Application no: H04/0594/02

Description: Proposed telecommunication equipment plus 15
metre high monopole

Location: Fruitex Storage & Distribution
Station Yard
Donington

Amendment: Revised position
Dwg.No. 02-D

CIVILS/STRUCTURAL DETAIL DESIGN
SOUTH EAST ELEVATION

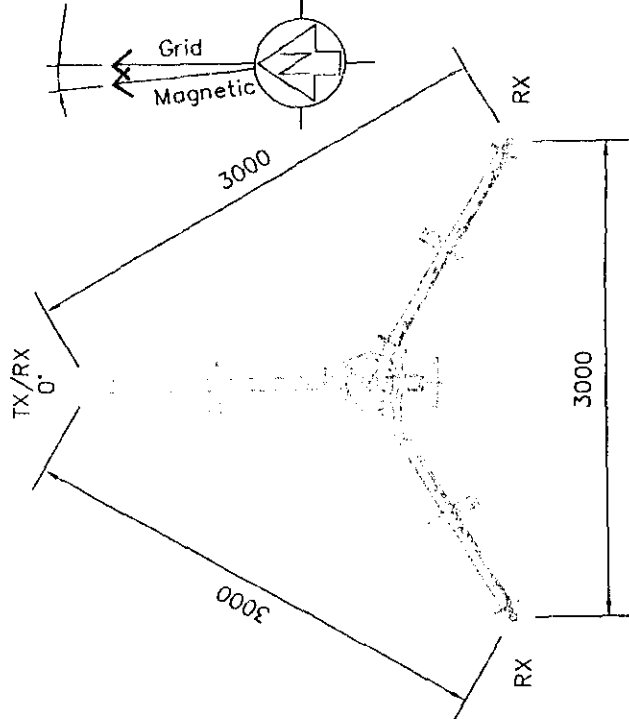
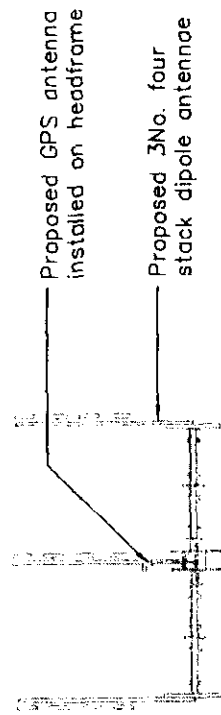
Amendment: Change height and diameter of dish
Dwg.No.MMD1752GF-LIN001.13B

Description: 1 no. 600mm transmission dish @ 10m in lieu of 300mm dish @ 15m.

The amended details submitted in respect of the above proposal have now been considered and there are no objections to the amendment being implemented to the extent described above.

Drawing Title
PLANNING DRAWING
PROPOSED SITE LAYOUT
SHEET 2 OF 3

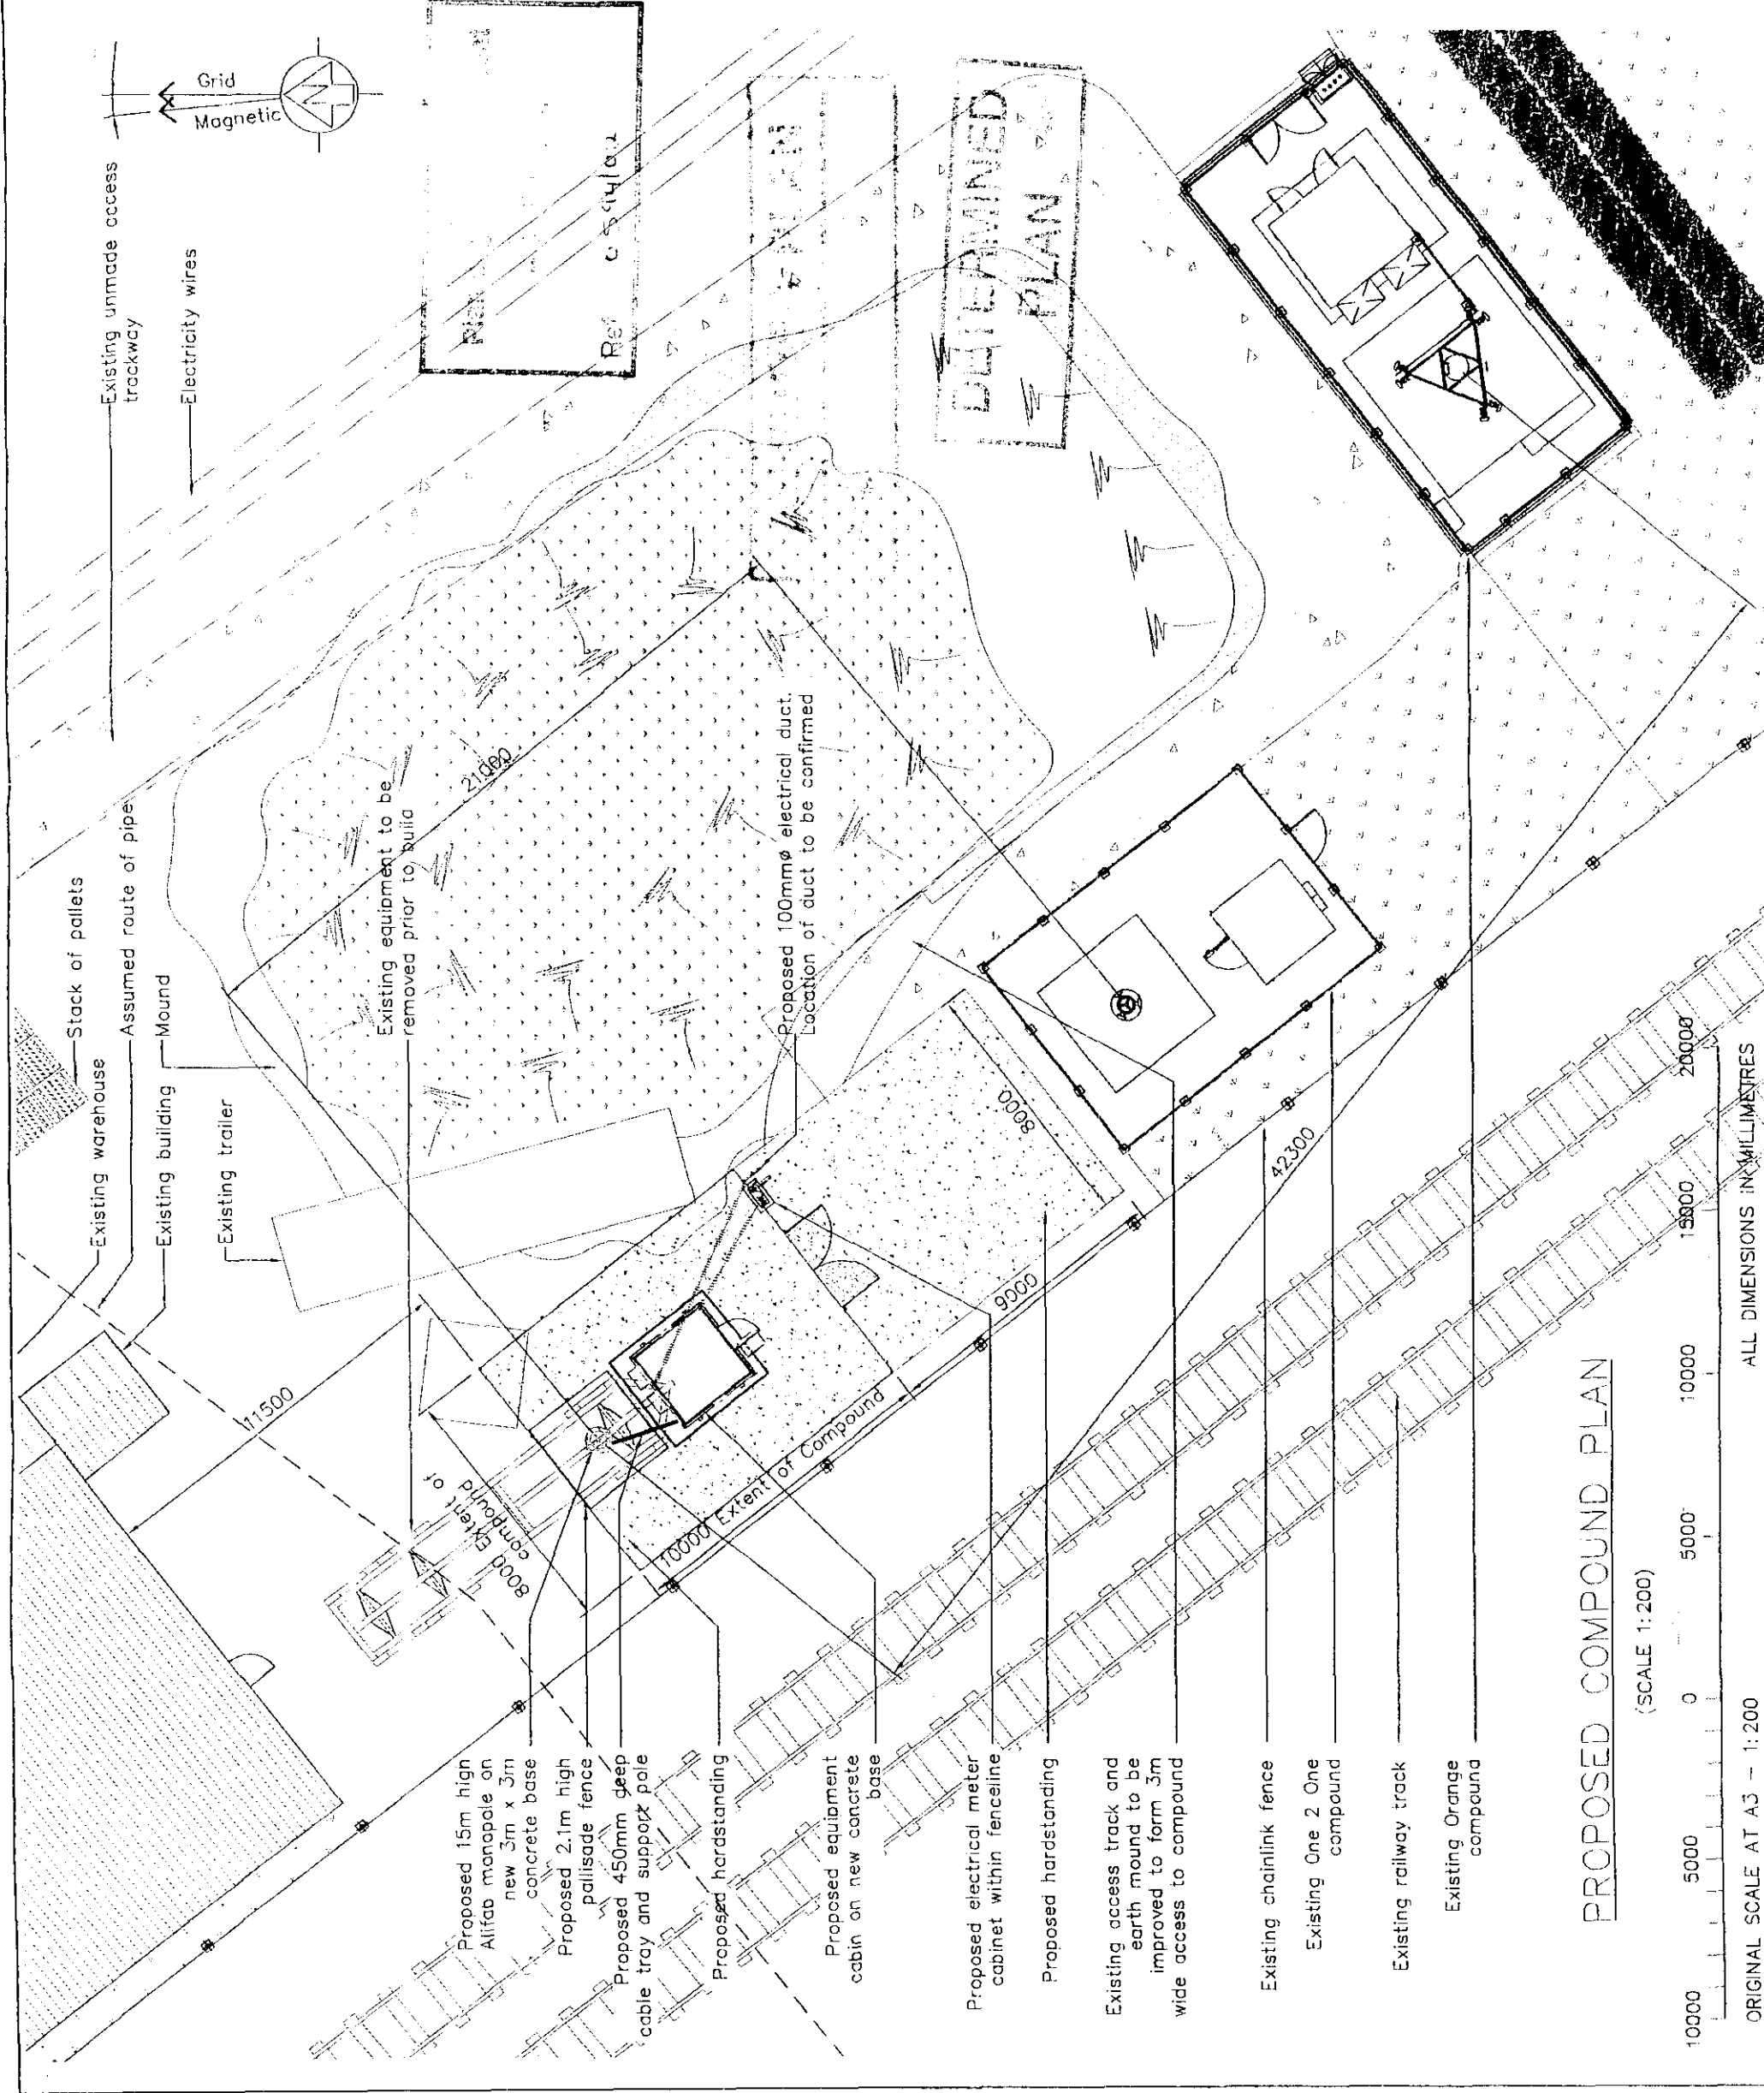
I have been in contact with The Local Planning Authority and our engineers. We have made the required amendments and I trust that the revised position now satisfies you.
